Address: 7 Highmoor Lane Cleckheaton BD19 6LW

| Application number: 2025/62/91542/E | |
| What is the application for?: | Erection of 40 dwellings and associated works, including formation of new vehicu |

| Type of comment: An objection | |

31236 100-P-001

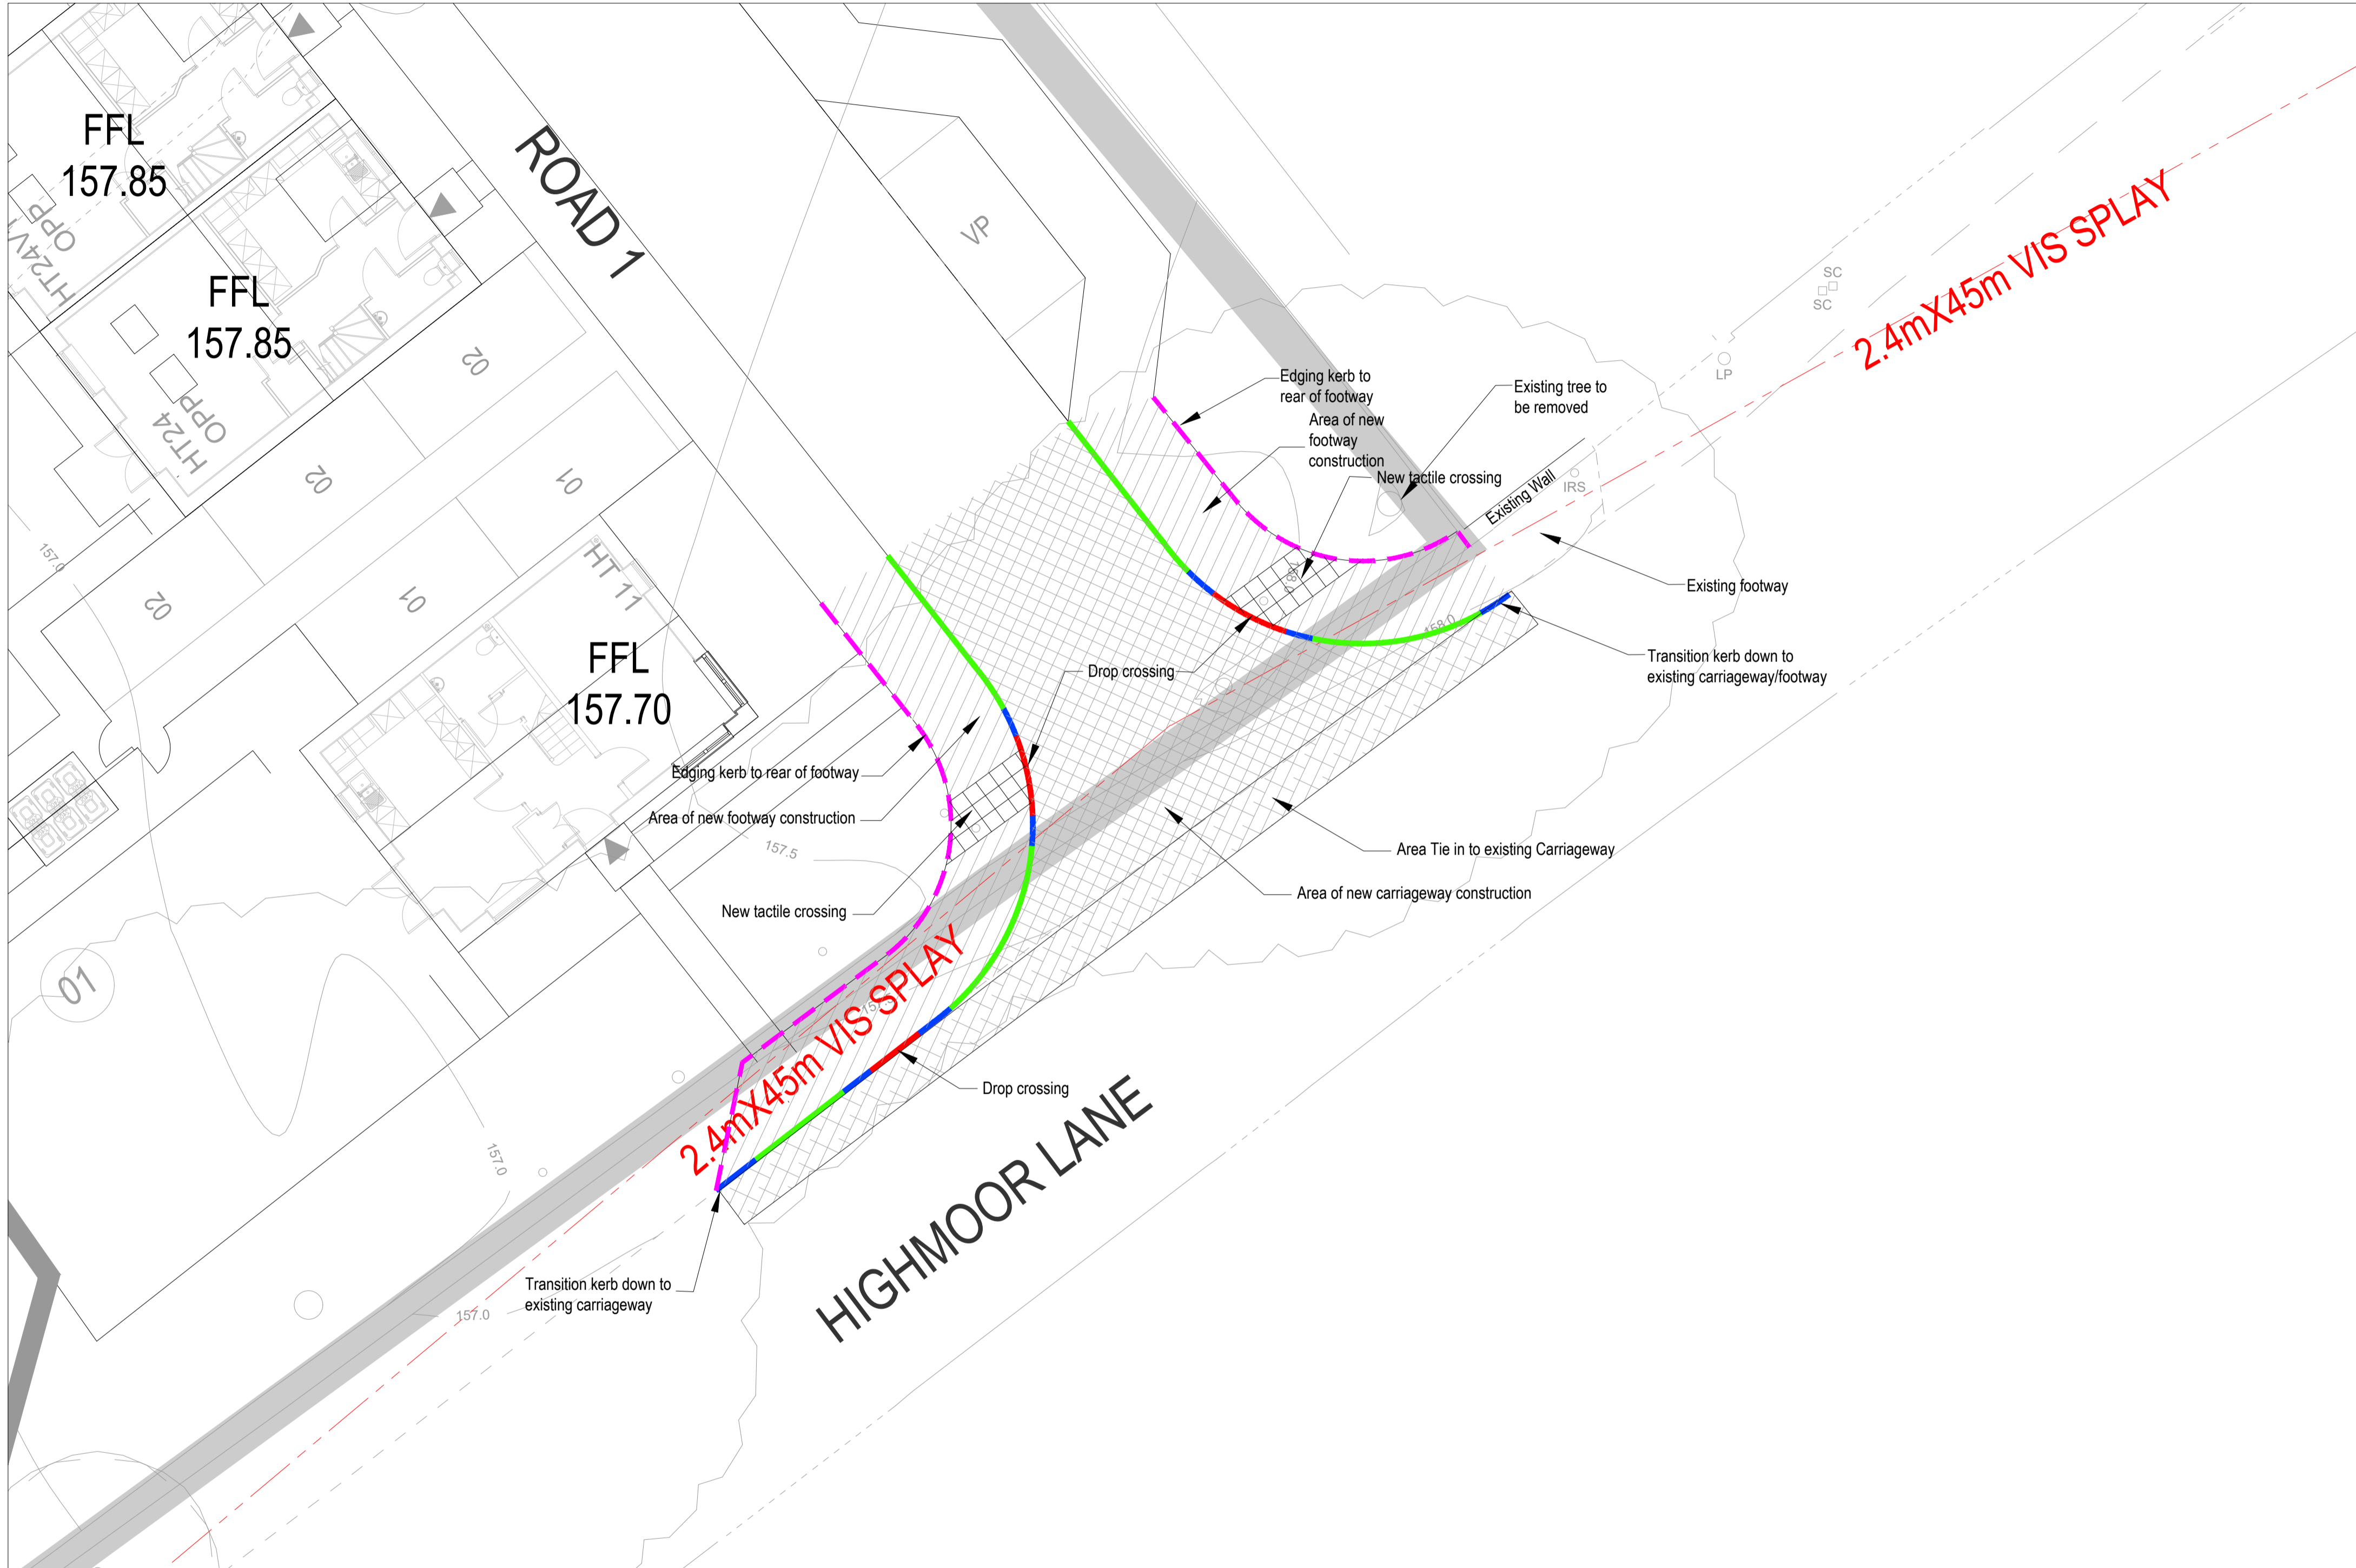
Had alternative access been suggested at the Local Plan stage both the residents and the inspector would have had the opportunity to examine the impact on the residential amenity, and both sites may not have been allocated if the issue was so severe. Alternative access for 40 homes, likely at least 80 regular vehicles, would be directly opposite the residents' homes causing light intrusion, increased pollution and increased noise.

1. Increased air pollution and noise by increased amount of queuing traffic at the traffic lights caused by the development.
2. The access will create light intrusion from car headlights into resident's homes from the new accessway.
3. The access is at a point in the highway where it narrows from 7.8 meters to 6.6 meters which makes exacerbates its inappropriateness.
